From: Beverley Odell [REDACTED]
Sent: 26 March 2012 12:24
To: Anita Gardner
Subject: Fw: FP/179/11/ - 30 Limmer Lane
Attachments: LimmerLane Rev16 Road Junction Plans (1).pdf, Speed Survey Results 2.pdf, LimmerLane Rev15 Road Junction Plans (1).pdf

I have received a response to my re-consultation with County Highways. He has stated 'The plan we viewed is not accurate due to the distortion of being printed, and due to this we are unable to scale. We would also need confirmation that the sight line to the west does not affect 3rd party land. In addition there was no indication on the speed survey data what direction each of the results referred to.'

#	LO	30/01/2012	1st Issue
Rev	By	Date	Rev
Client John Owen			
Job 30 Limmer Lane Felpham, Bognor Regis, West Sussex.			
Drawing Proposed Apartments Highway works and Visibility			
Date	January 2012	Scale	1:100@A1 1:200@A3
Drawn By L.O.		Dwg. No. 030510/SL-40

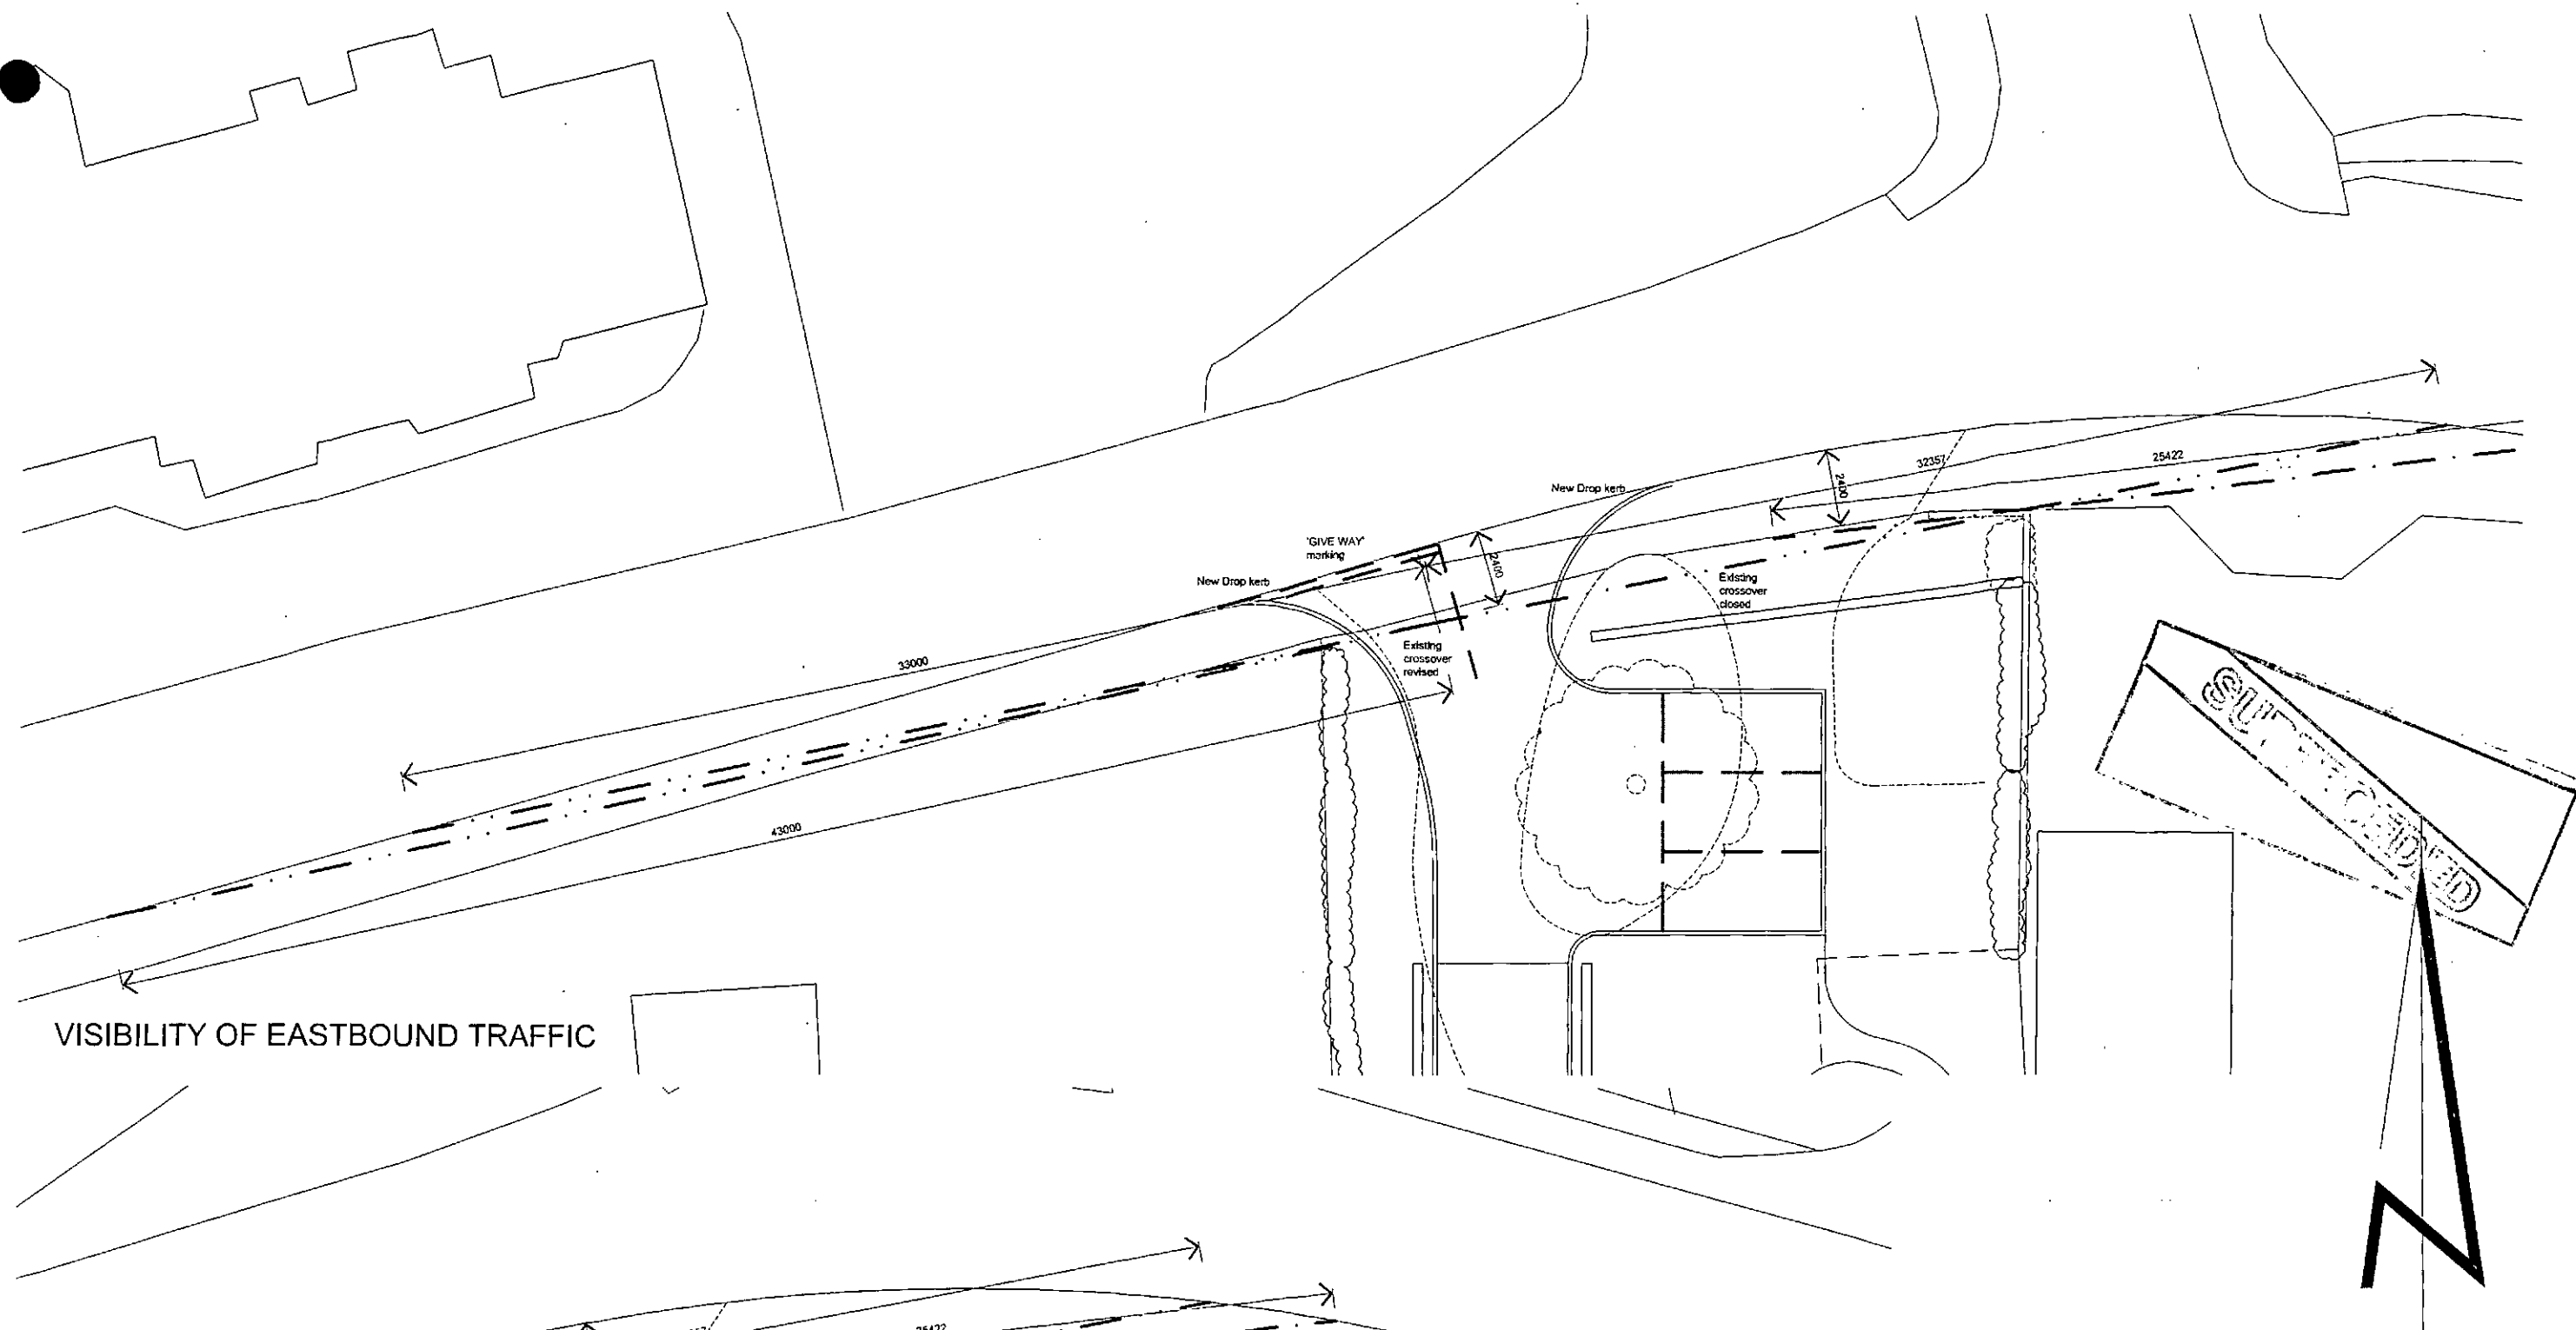
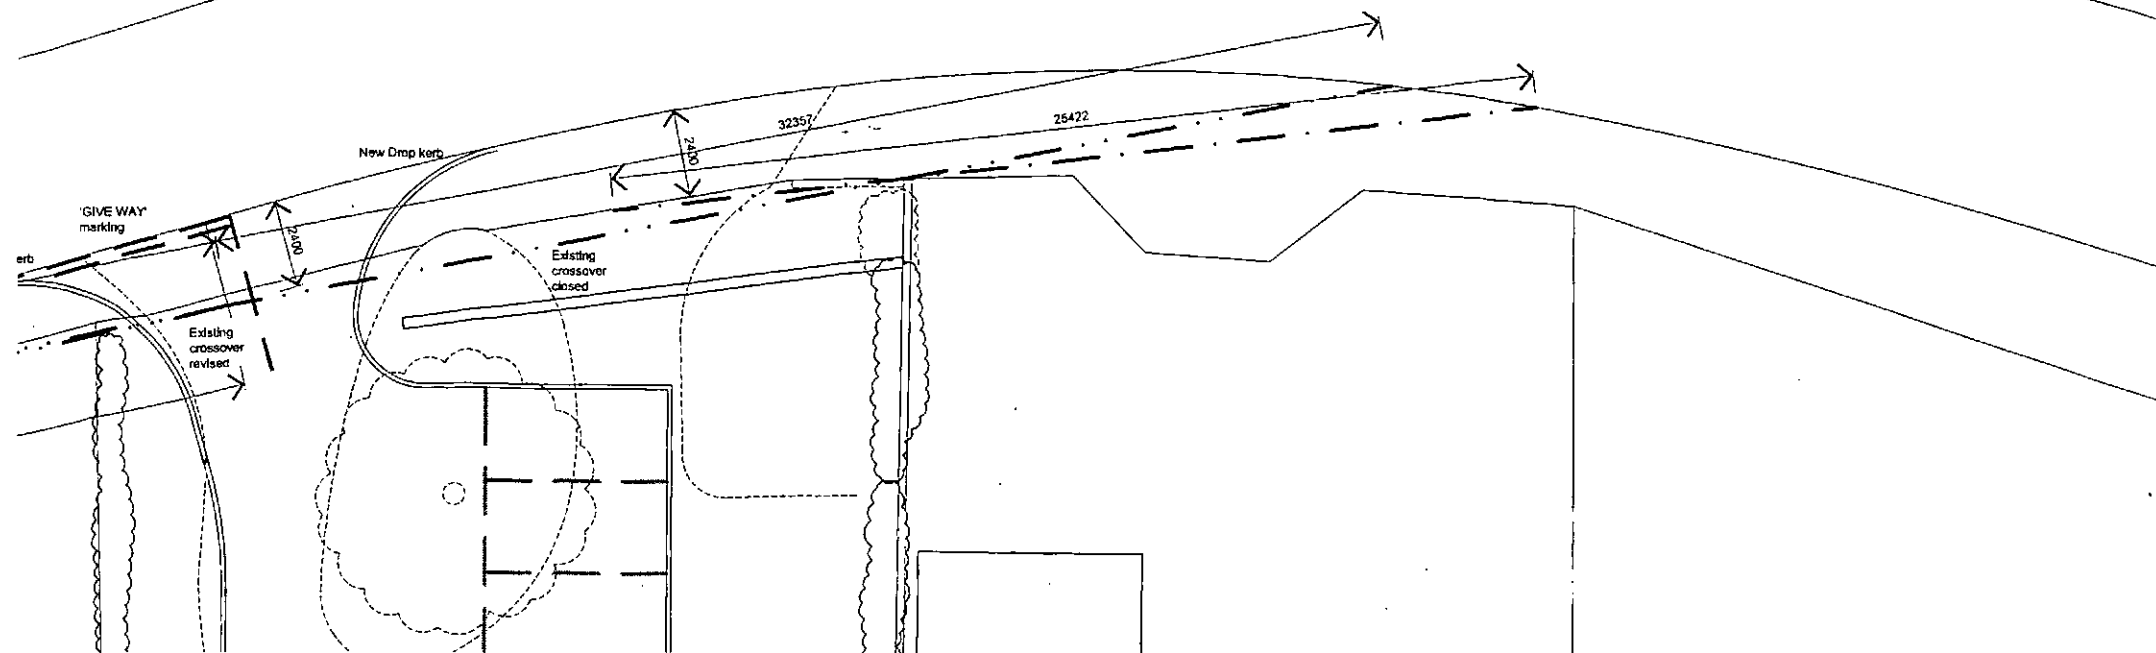
Manual for streets gives SSD's of 25m, 33m and 43m respectively for 20mph 25mph and 30mph 85th percentile speeds.

If interpolated correctly between 25 mph and 30mph for the surveyed average 85th percentile this would give a required SSD of 37.750m

Our current proposal for the junction gives a visibility 'Y' distance of 33m and with some minor adjustment can be altered to give 37.75m (or very close to it)

I think you will agree that a visibility sight line improvement from 27m to 35m or more must be considered as beneficial to both the site and existing highway users even with an increase in traffic entering and exiting the site post development. In risk assessment terms a high risk can be reduced to a low / very low risk albeit with a small increase in frequency of said risk.

Attached are pdf version of the junction drawing as submitted along with junction drawing showing a revised distance of 2.0m rather than 2.4 for your consideration.
